From: Andrew Wood
Sent: 14 March 2019 10:44
To: Karen Parsons
Subject: FW: Planning Application FG/220/18/PL : Land adjacent to Elm Lodge, Tamarisk Way, Ferring, West Sussex BN12 5ER
Attachments: Re_Planning Application FG_220_18_PL _ Land adjacent to Elm Lodge, Tamarisk Way, Ferring, West Sussex BN12 5ER.eml

Further to Laura Gibbons' out of office email message below, we have been in discussions with Laura regarding the above application and agreed an extension of time with Andrew Wood until 8th March 2019 to enable us to address Laura's objection regarding the impact of the proposed detached chalet-style dwelling on the existing pond. I have forwarded our correspondence below for your information.

In order for me to remove my objection I am going to need some further information to be supplied:

EXISTING POND ACCESS
PLAN

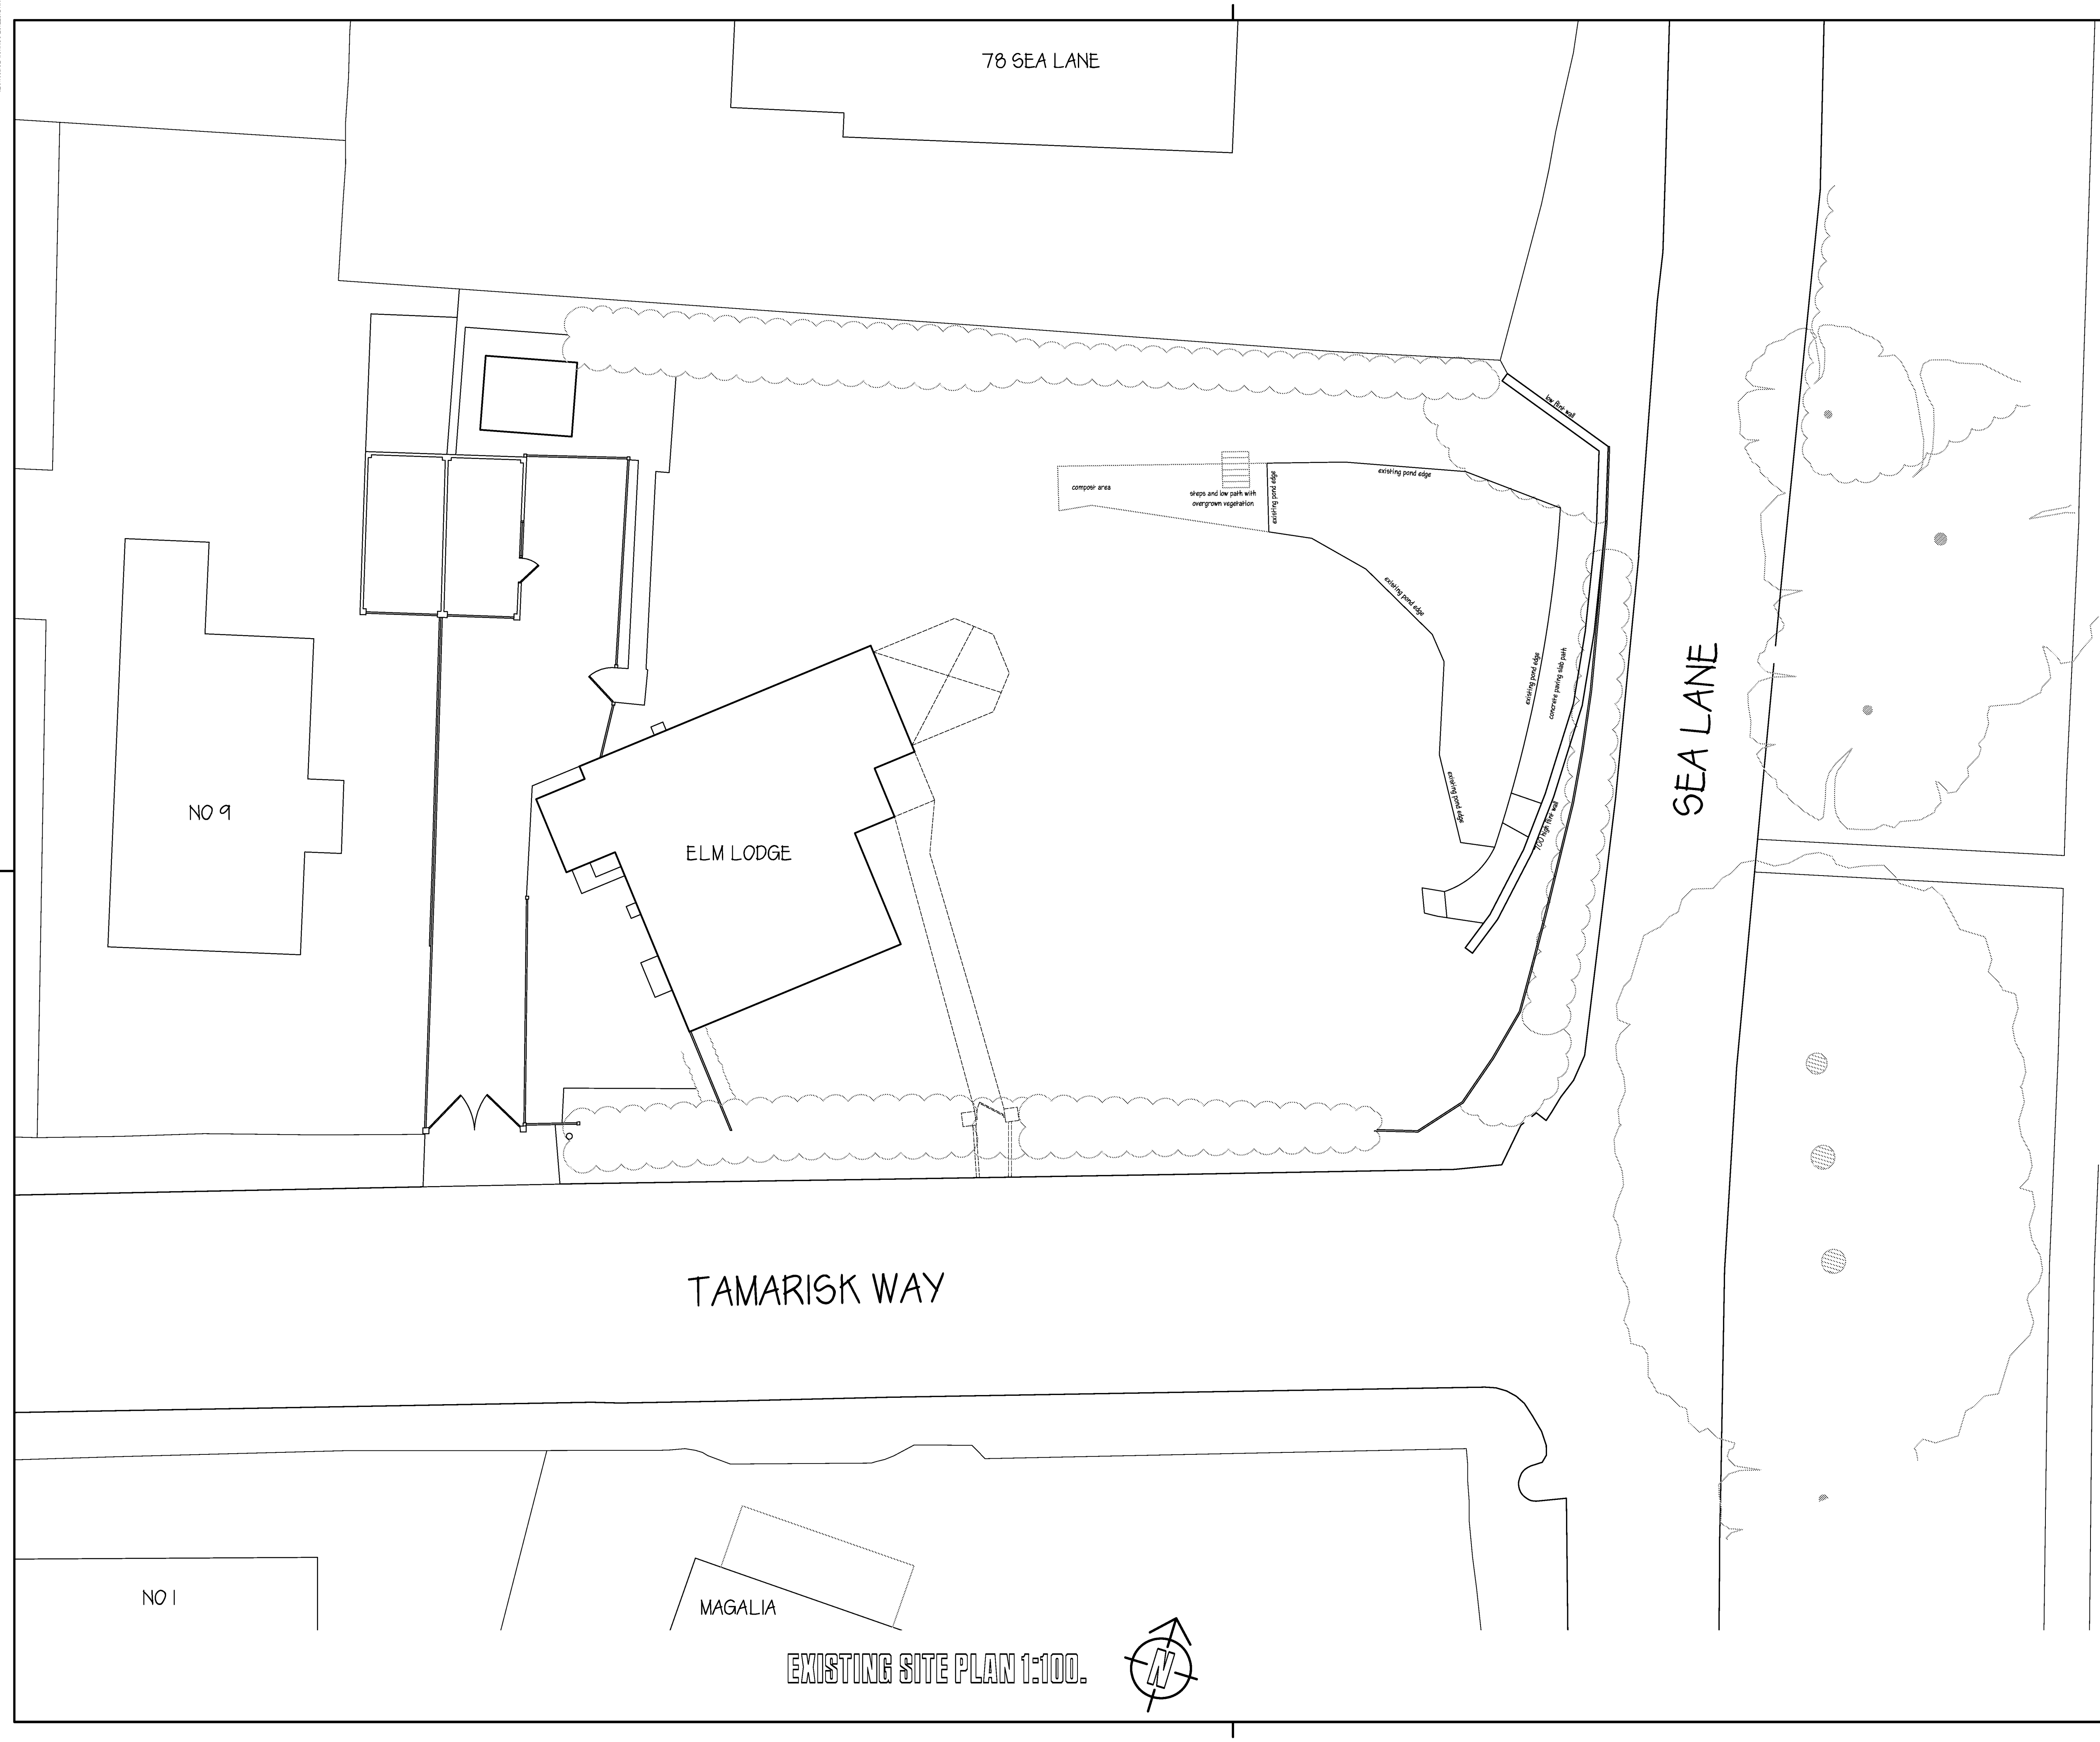
3. It is my belief that there is no way to get to the northern and western portions of the pond without tracking through the pond itself. This would mean that maintenance would have to be completed in the summer by the landowner when water levels are lower. This would then be within nesting bird season. I would much prefer an access to be provided around the pond. I note that you state the 1m wide path to the east could take plant but this plant would not be big enough. As explained above, we as landowners can continue to access the pond from all sides, with 3m to the West, North and South East. We cannot understand what plant would ever be required (given no plant has ever needed to access the pond before, and any plant necessary for carrying out works to the pond can have full access from all sides as part of the building works) that would ever be larger than a small digger, which can easily be maneuvered up the 1m side access to the west of site and around the rear. You are going to need a large digger to access the pond and clear it of vegetation and silt. The size of machine is dictated by the depths that excavation need to be carried out to, the size of plant that can fit along a 1m path would not be sufficient to carry out the excavation required. Ongoing maintenance will be required after construction is complete, this is when the proposed site layout in my opinion would prevent this work.

4. It also needs to be demonstrated that the volume of pond to be infilled will be compensated for elsewhere. We will not be infilling the pond. The pond is to be retained as existing. The only part we are looking to change is the path to the west of the pond, which will have new turf added over the existing overgrown vegetation. This will not affect the volume of pond since there is no water in this area. We are happy for you to condition the application to ensure the pond is not infilled. In flood conditions the area that is currently used as a compost heap provides volume for water storage, this would be lost with your current proposals.

Regarding your point below that "In flood conditions the area that is currently used as a compost heap provides volume for water storage, this would be lost with your current proposals", there is no history of any flooding on the site, or water breaching the current edge of pond. We would be infilling this small area of land with soakaway crates, designed by specialists, to ensure it can still hold any excess water under the new turf covering.

Drawing Title **PROPOSED POND ACCESS
PLAN**

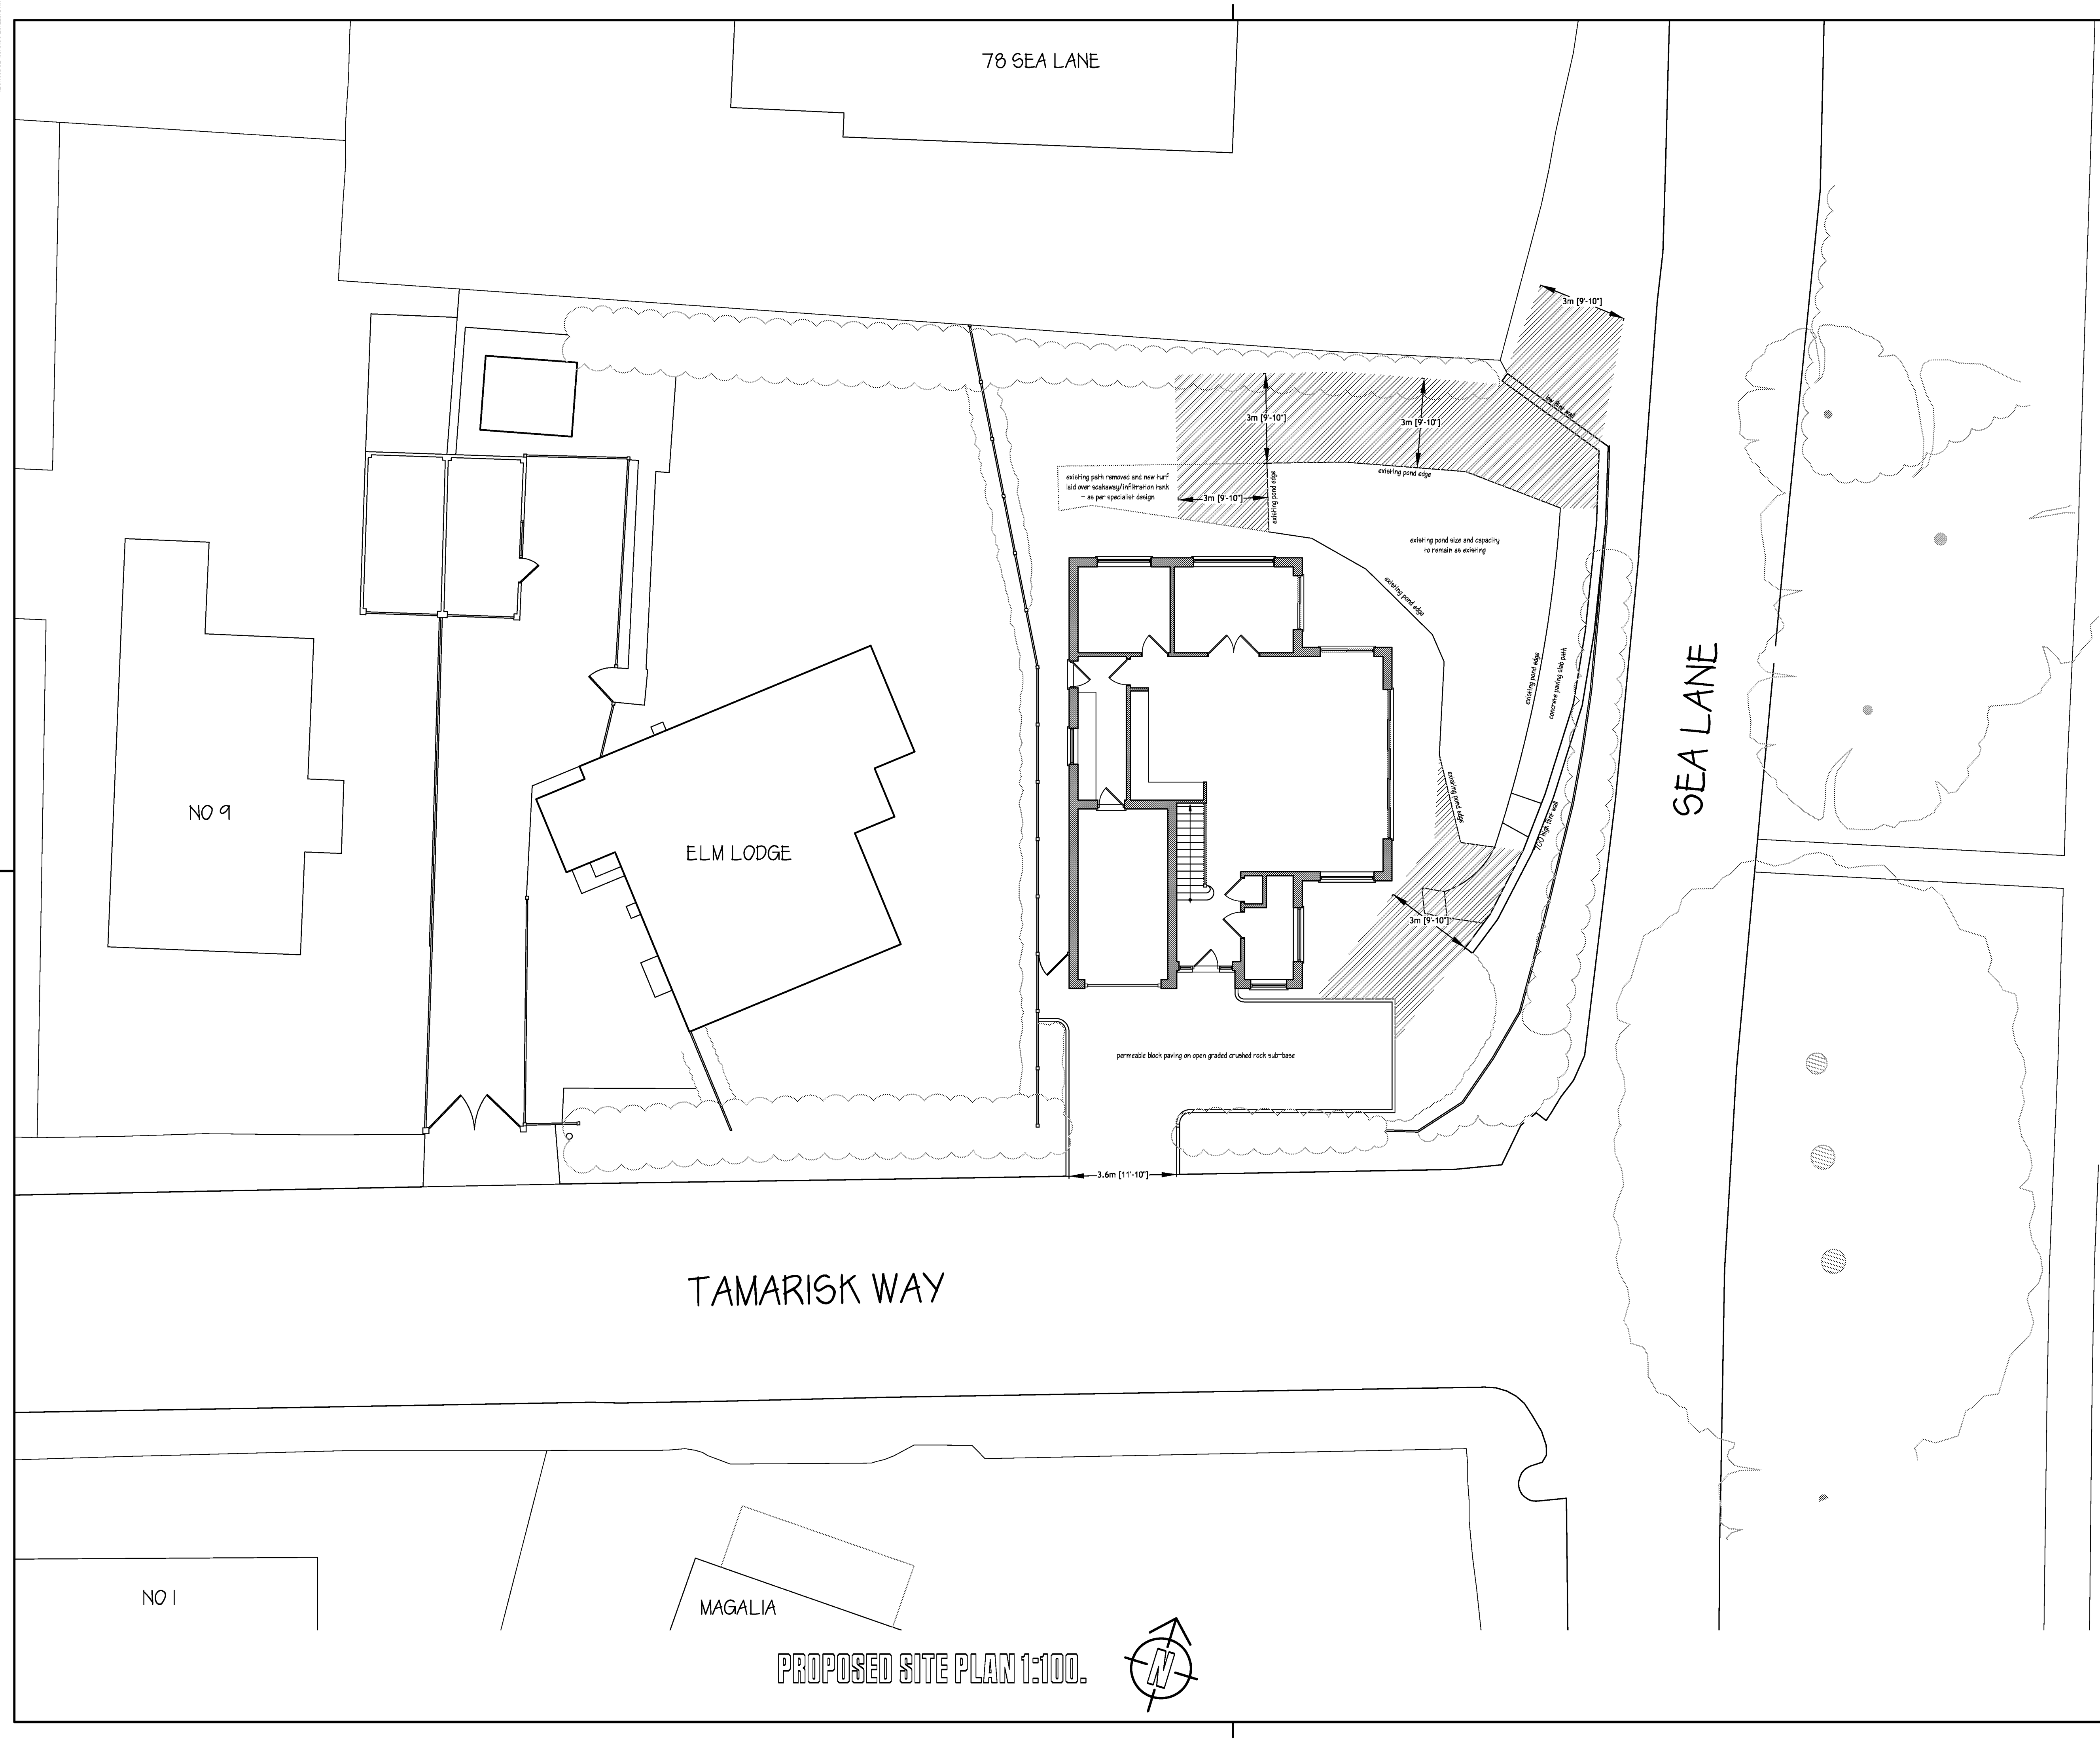
1. Please identify whether a pipe exists at the western extent of the pond. This will impact upon if I believe there is a likelihood you will have sufficient space for surface water drainage. The soakaway that you are currently proposing is located directly on top of the suspected pipe location. We will be able to identify the location of any potential pipe as part of a pre-commencement condition. We agreed that we could also submit details of proposed soakaway locations as part of the pre-commencement conditions relating to surface water drainage, once potential for soakaways had been adequately assessed, calculated and positioned by a civil engineer. It is likely the 100mm diameter soakaway pipes would be at a higher level if crossing over any existing pipe from the pond, therefore may not impact any existing pipe, although we would ensure this is checked by a civil engineer and approved by ADC as part of the pre-commencement condition. My concern is that there may not be sufficient area within the site to drain the new impermeable areas. I acknowledge your point regarding crossing over of pipes, however there is then no real room to get 5m from your building and 2.5m from the property boundary to site a soakaway which will likely be quite large in plan area.

2. I am not keen to see the building go up to within 0.8m of the pond. Access and erosion are both a concern. I would therefore be keen to see the building layout revised to provide more easement. As shown on the proposed indicative part foundation section detail, short bore piles would be positioned a minimum of 3m from any edge of the pond, reducing the risk of erosion by eliminating trench foundations. Given a specialist would be designing the reinforcement/camp shedding for the existing edge of the pond (again, to be agreed with ADC by condition prior to commencement), this would ensure there will be no erosion. Given the building would only be cantilevered at one point within 0.8m of the pond, there is still a large area of access

around the east and all other parts of the pond. We note that ADC has never had to access the pond to carry out any maintenance works to date, therefore query why there is such an onerous requirement for access now. We also note that ADC cannot currently access the pond with plant, since we have gates to the property and a further gate at the rear which would obstruct machinery from accessing our garden to carry out any maintenance works at all. ADC would have greater access to the pond as a result of the proposal, given there would be no obstruction when entering from the driveway. ADC Bylaws state that "Riparian Owners are responsible for maintaining the watercourse and any associated structures (i.e. headwalls, screen, weir etc.) and primarily to keep them free of any obstructions that may impede flow in the watercourse". There will be no obstructions which impede the flow in the watercourse, as demonstrated. We can easily complete any pond works to ensure it is upgraded from its current state (which has not been identified as obstructed or badly maintained by ADC to date) before commencement of any building works on site. The bylaws state that "Arun District Council may decide to exercise the permissive powers if it is approached by property owners affected by badly maintained or obstructed watercourses and they have been unable to get a 'riparian owner' to carry out necessary works. In the first instance, Arun District Council will try to resolve the problem informally by explaining 'riparian ownership' responsibilities and agreeing the work that is required to the watercourse to rectify the problem. If this approach is unsuccessful, Arun District Council may require and enforce 'riparian owners' to carry out works using powers under S25 of the Land Drainage Act 1991 where the flow of water is impeded and the condition needs to be remedied." Given we as riparian owners will be able to access the pond from all sides to carry out any works in accordance with the bylaws, we do not understand why ADC would need access to our land, particularly from multiple different points given they cannot access it at all at present. It is the landowners (Riparian) responsibility to complete maintenance works, if we are informed of an impediment to flow we request landowners complete this maintenance. If they refuse to complete the work, we use our powers under S25, and this can be accompanied by forced entry through gates. The proposed layout will make it exceptionally difficult to complete maintenance. Irrespective of planning it is fairly evident that an impediment to flow is present, so we will be requiring you as landowners to complete maintenance to the pond to ensure silt levels are reduced and culverts are in an appropriate condition. Ongoing maintenance (including to any retaining walls) will be required after construction is complete, this is when the proposed site layout in my opinion would prevent this work.

In order to hopefully alleviate your concerns, I attach an alternative proposal to reposition the proposed dwelling to provide greater access around the pond for future maintenance and minimise the risk of erosion resulting from the works. Please could you let me know your thoughts on the attached proposal, and whether this solution would be acceptable? If so, we can then amend the planning application drawings for Andrew accordingly.

Further to our meeting at the land adjacent to Elm Lodge, Tamarisk Way, Ferring, West Sussex BN12 5ER on 12th February 2018, please find attached the existing and proposed pond access plans as requested. These show the existing pond to be retained in its entirety, with 3m access provided should Arun District Council ever need to access our property to maintain the pond. We hope these now alleviate your concerns regarding potential future access. We also note that the path to the east of the pond is also over 1m wide, which can currently comfortably accommodate a 1.5 ton digger to carry out any works. Given that there are multiple points of entry along the edge of the pond, any further work can be carried out from within the pond.
